Re: Wellborn Paint Store  
Drainage Report  
As-Built

RE: CERTIFICATION FOR WELLBORN PAINT STORE AT JUAN TABO  
(J-22/D34) RECEIVED FEBRUARY 26, 1985

RE: WELLBORN PAINT STORE CERTIFICATION  
(J-22/D34)

AS-BUILT DRAINAGE REPORT FOR 1416 JUAN TABO BLVD. N.E. ALBUQ., NEW MEXICO

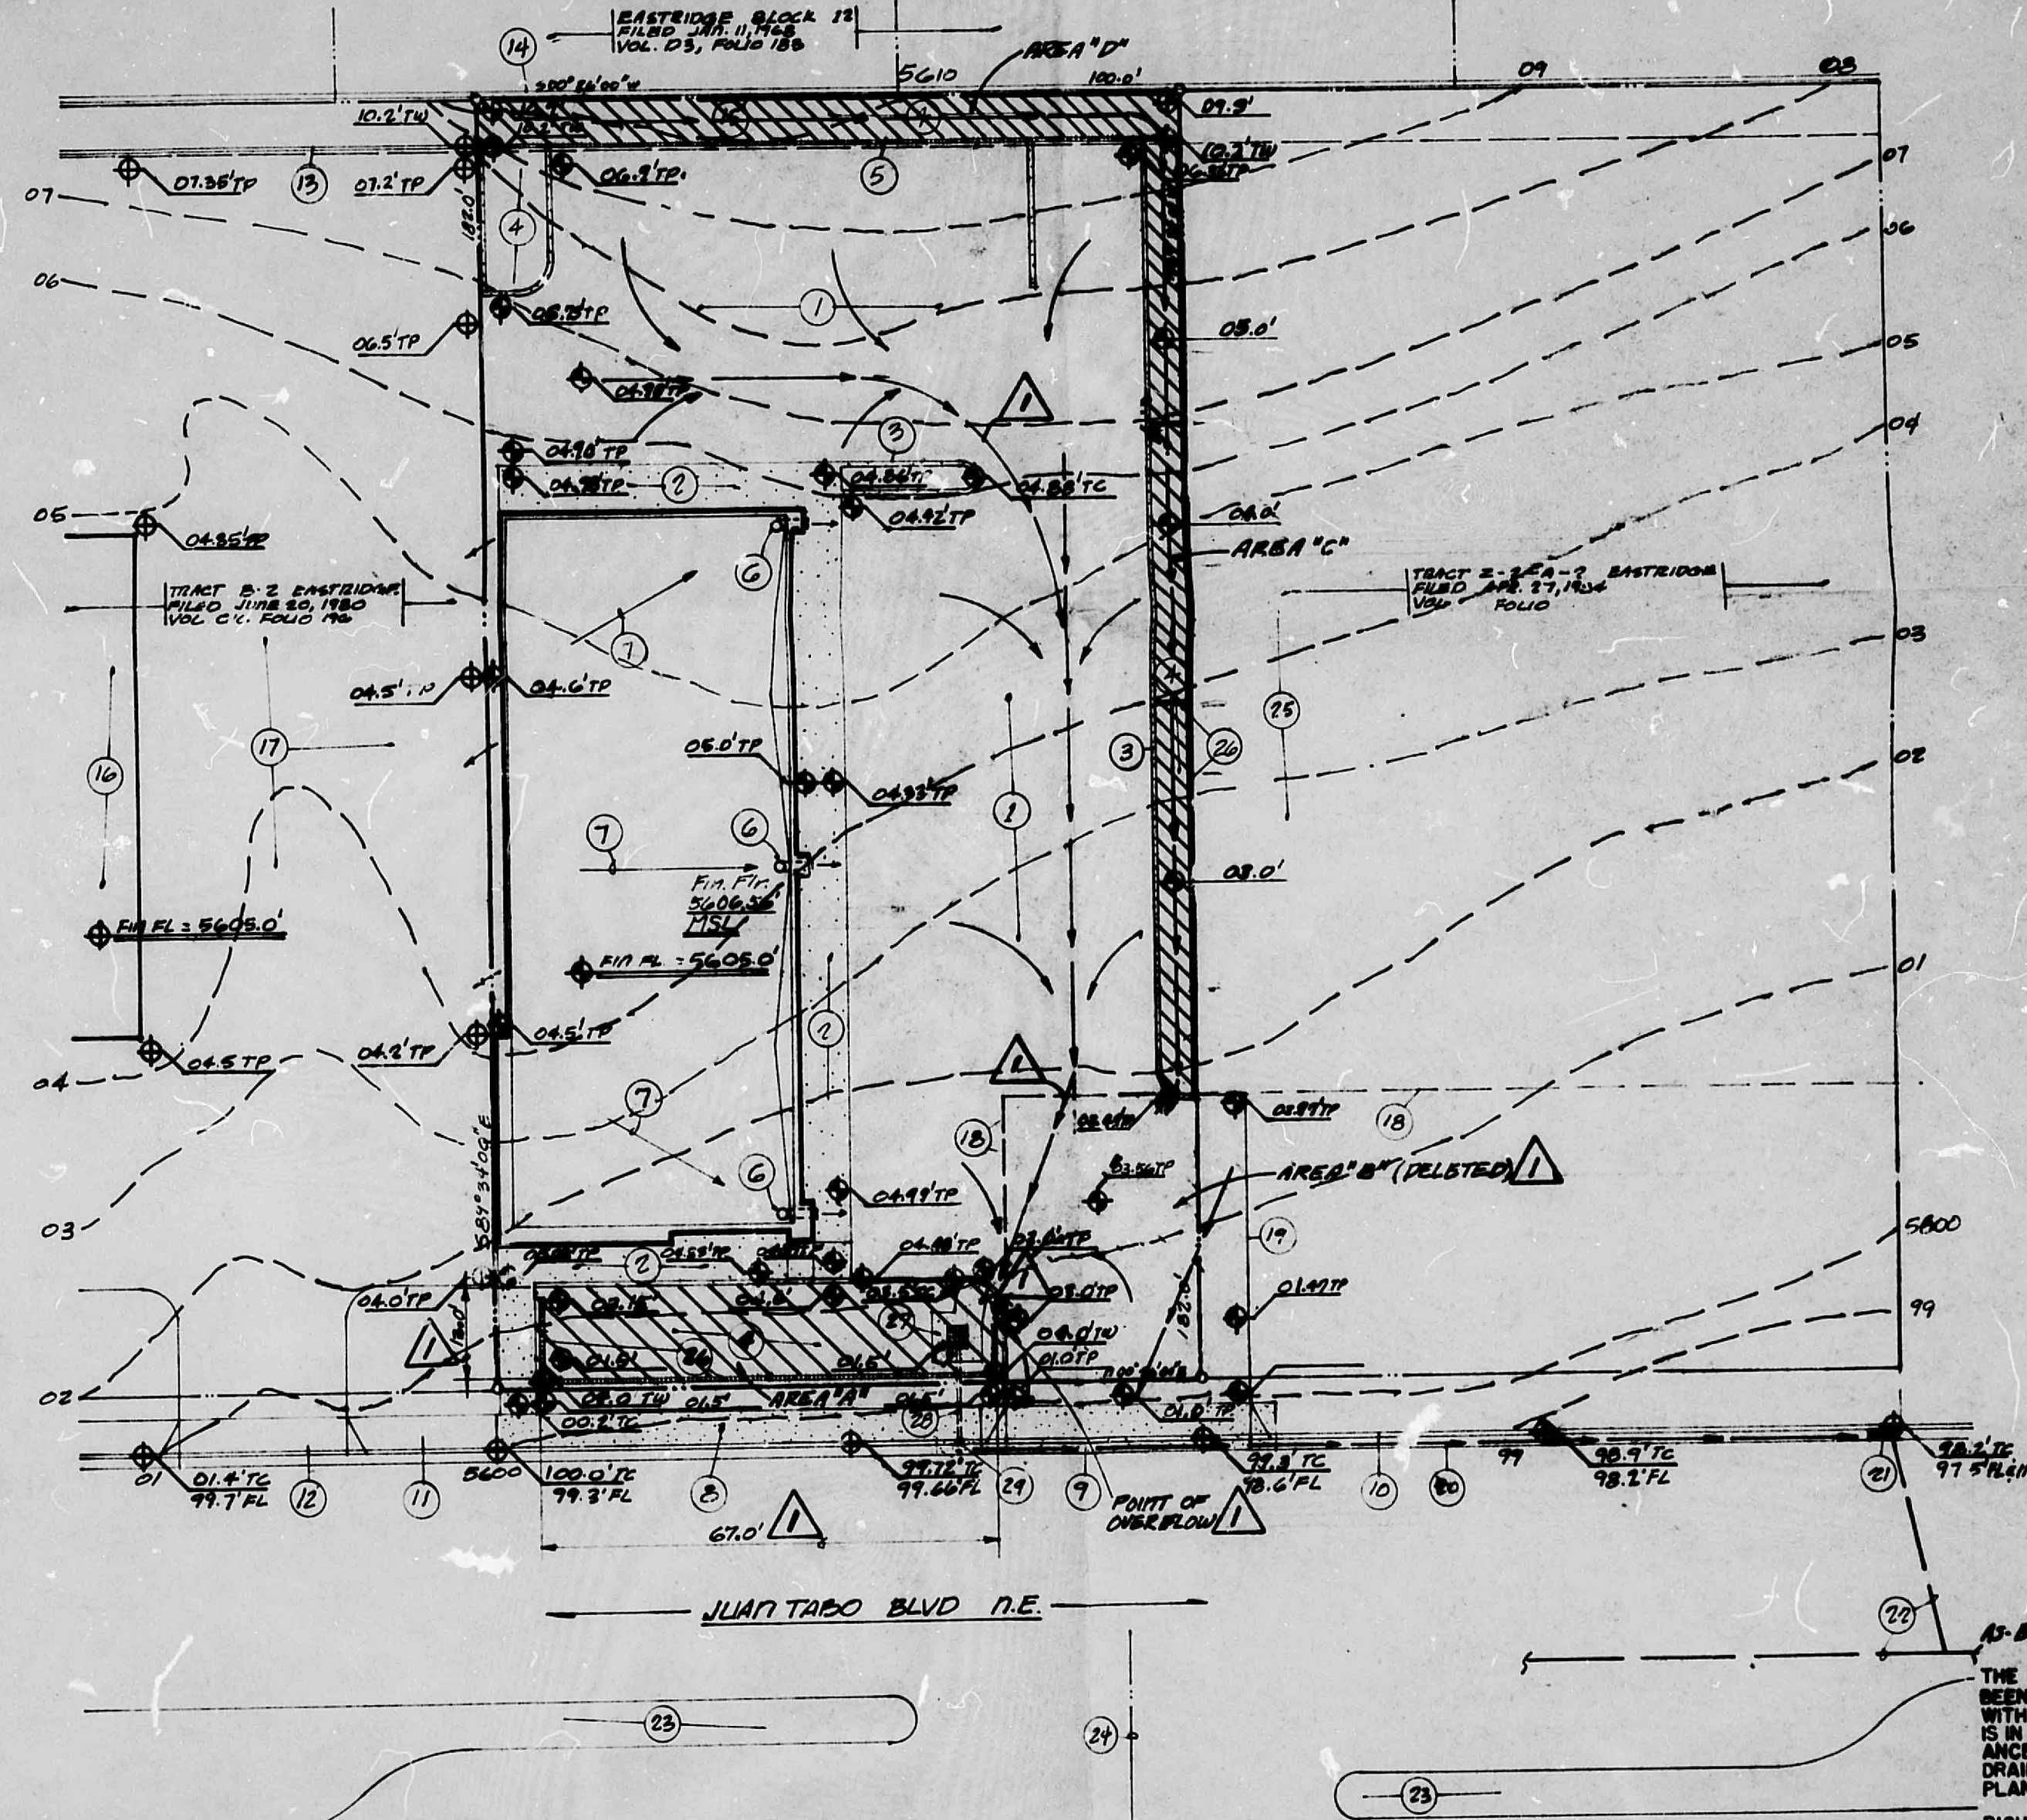
1. New information sheet designating resubmittal for certification.
2. Professionals Certification - engineer's stamp dated and signed accompanied with a statement indicating substantial compliance with the approved drainage report and/or plan.
3. Provide copies of construction approval from the appropriate government agencies for construction within their right-of-ways and/or easements.
4. Waterproof membrane within ponding area has not been addressed.
5. Your as-built grades within the ponding area are the same as the original approved grades. Pond does not reflect that it was lowered to accommodate the flows from area B and C.

6. Include pt. where emergency spillway will occur if inlet was to get plugged.
7. Please provide as-built dimensions and grades for pond area A.

- 1) See attached.
- 2) The grading and drainage plan sheet has been stamped, dated, signed and noted as required.
- 3) City inspection was approved Nov. 2, 1984 and forwarded to Hydrology on Nov. 8, 1984. It was received by hydrology that same day. See attached.
- 4) The waterproof membrane has been installed as shown in the as-built section view of the grading and drainage plan.
- 5) Yes, the as-built ponding grades are the same as the original approved grades because the pond bottom was not lowered. Instead of lowering the bottom to accomodate the additional inflow, the walls were raised. See as-built wall elevations on grading and drainage plan.
- 6) It is now shown in proper location.
- 7) See as shown.
